# CITY OF ALBUQUERQUE

**Re: Marble Brewery-New Building Addition**  
**111 Marble Ave NW**  
**Request Temporary 90-day C.O. - Accepted**  
**Engineer's Stamp dated: 9-1-15 (J14D140)**  
**Certification dated: 2-4-16**

1.	09/1/2015	Rev. Tanks and Update Pond
MARK	DATE	DESCRIPTION
ISSUE:		DRB AA 2014
PROJECT NO:		1407
CAD DWG FILE:		
DRAWN BY:		
CHECKED BY:		
DATE:		8/25/14
SHEET TITLE		
GRADING & DRAINAGE PLAN

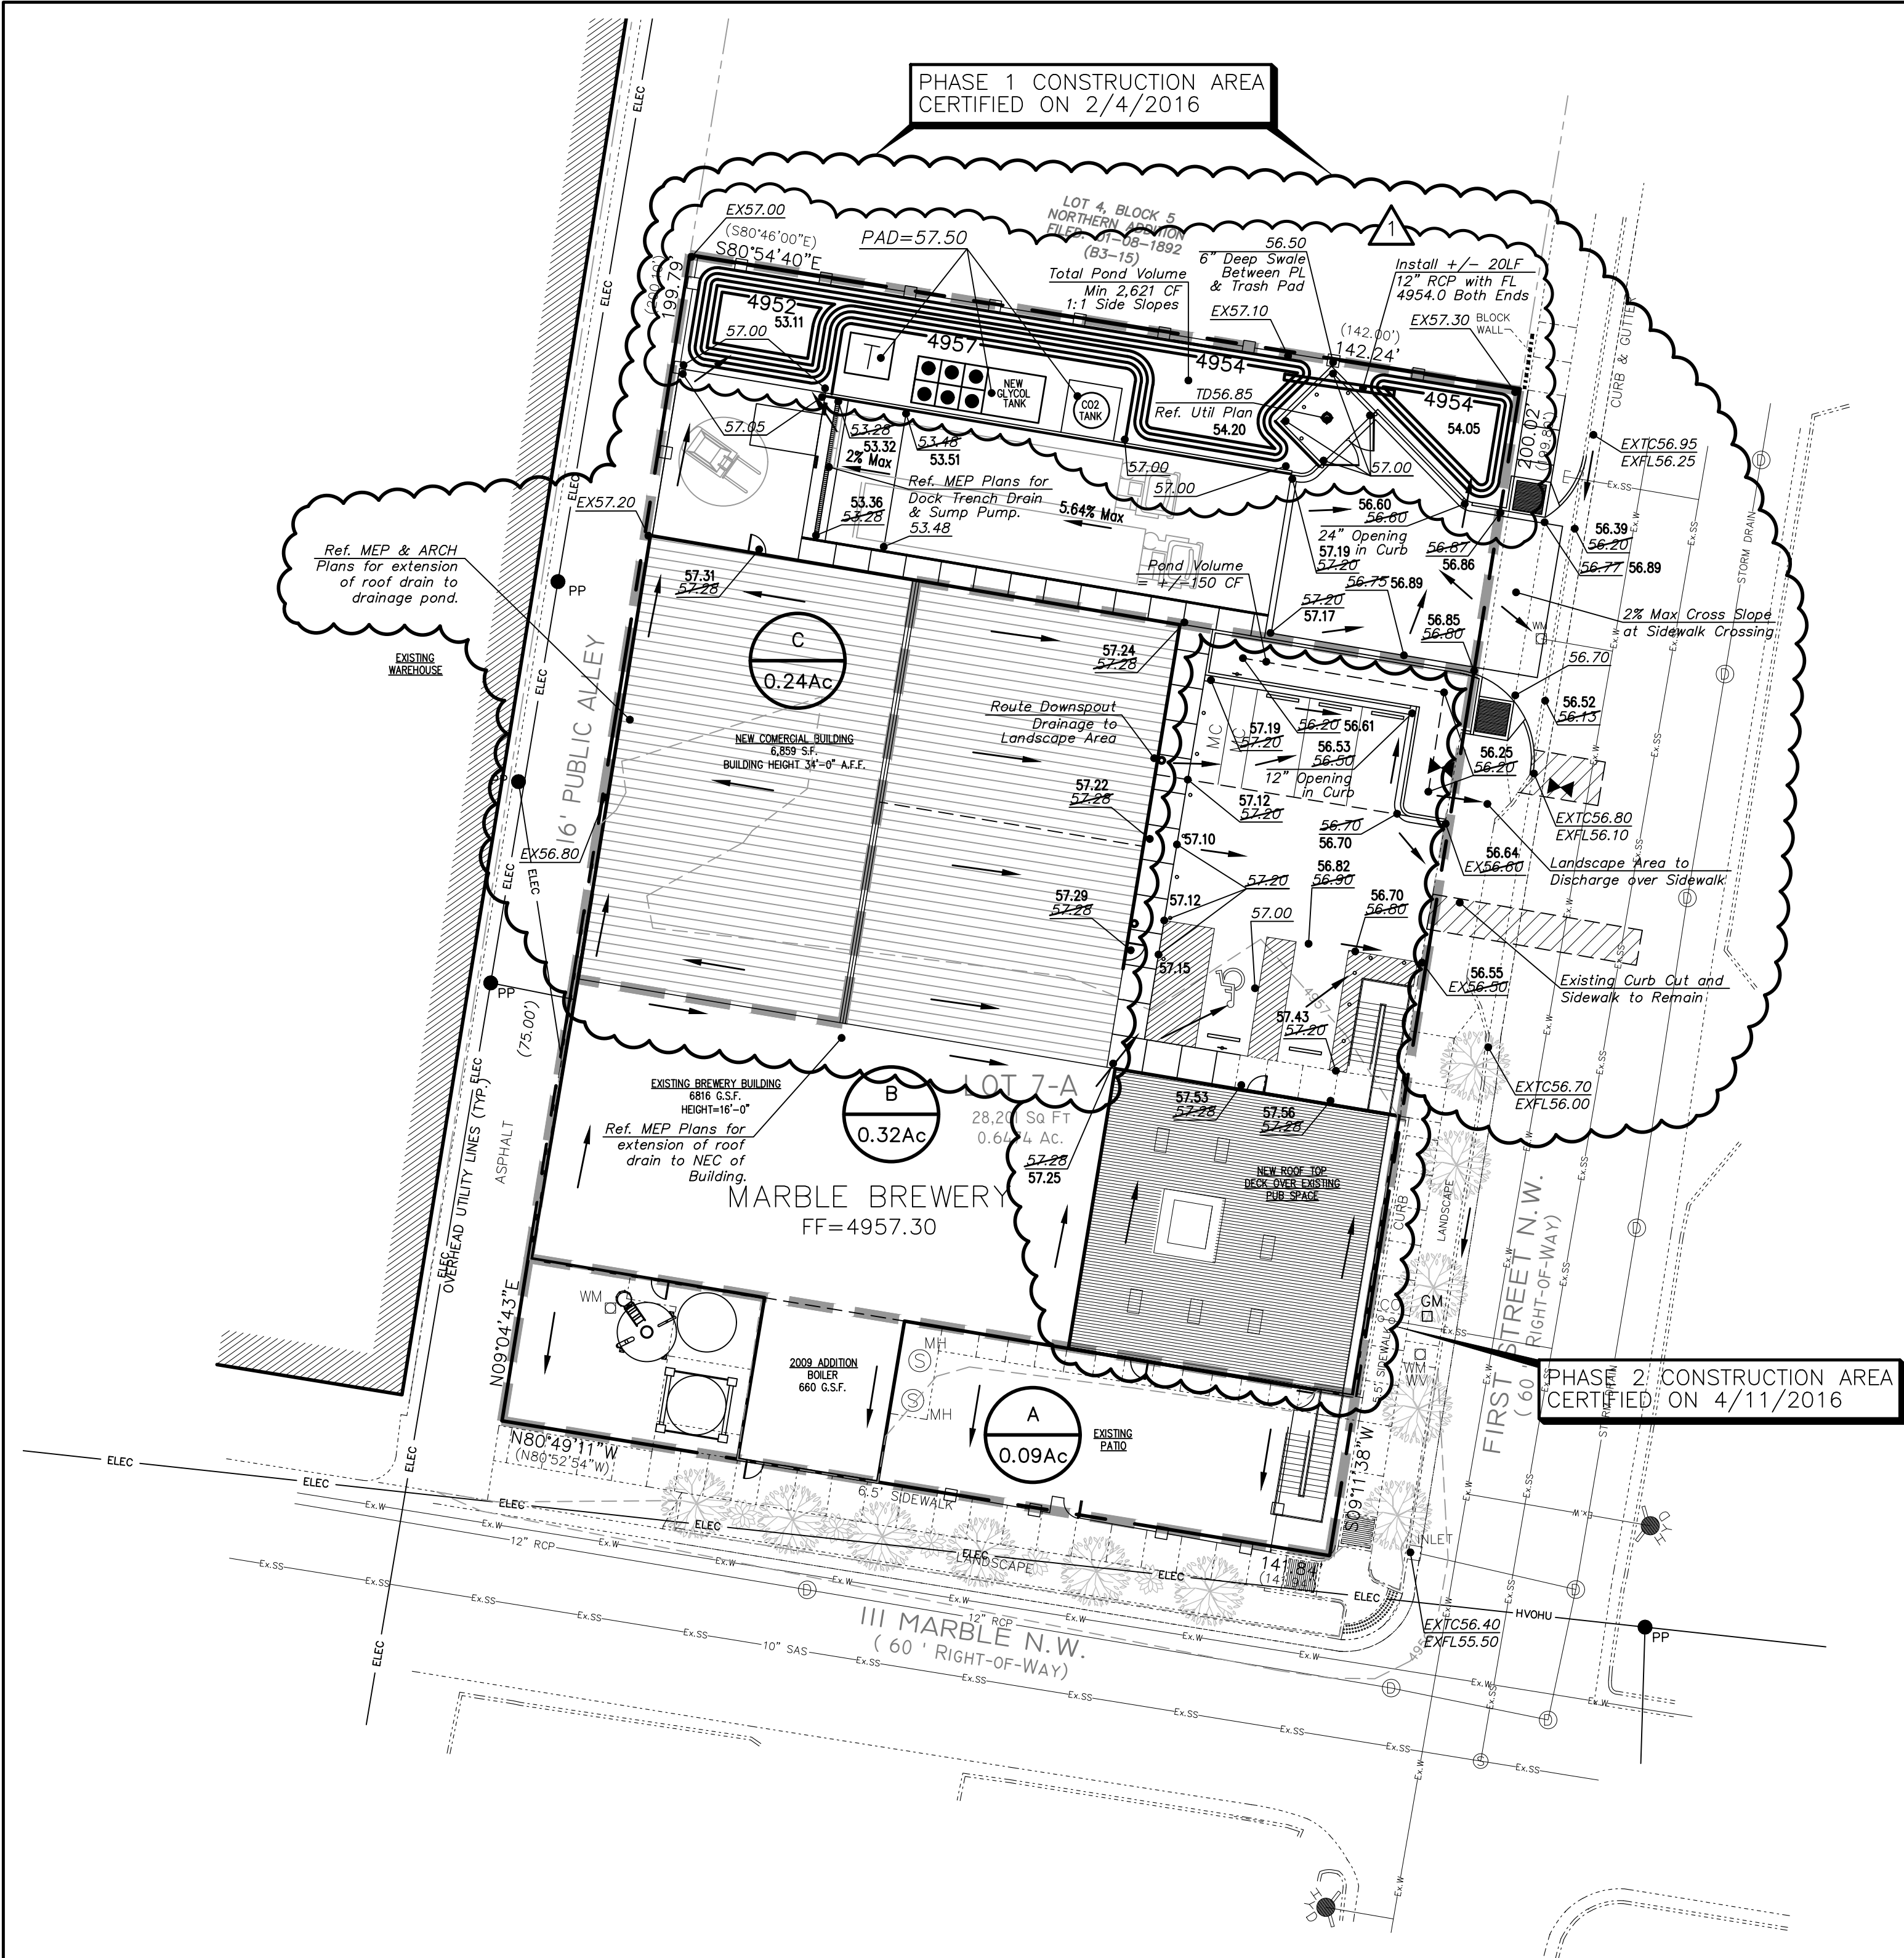
- Call out on as-built change in the dock trench drain.
- Complete construction of parking lot.
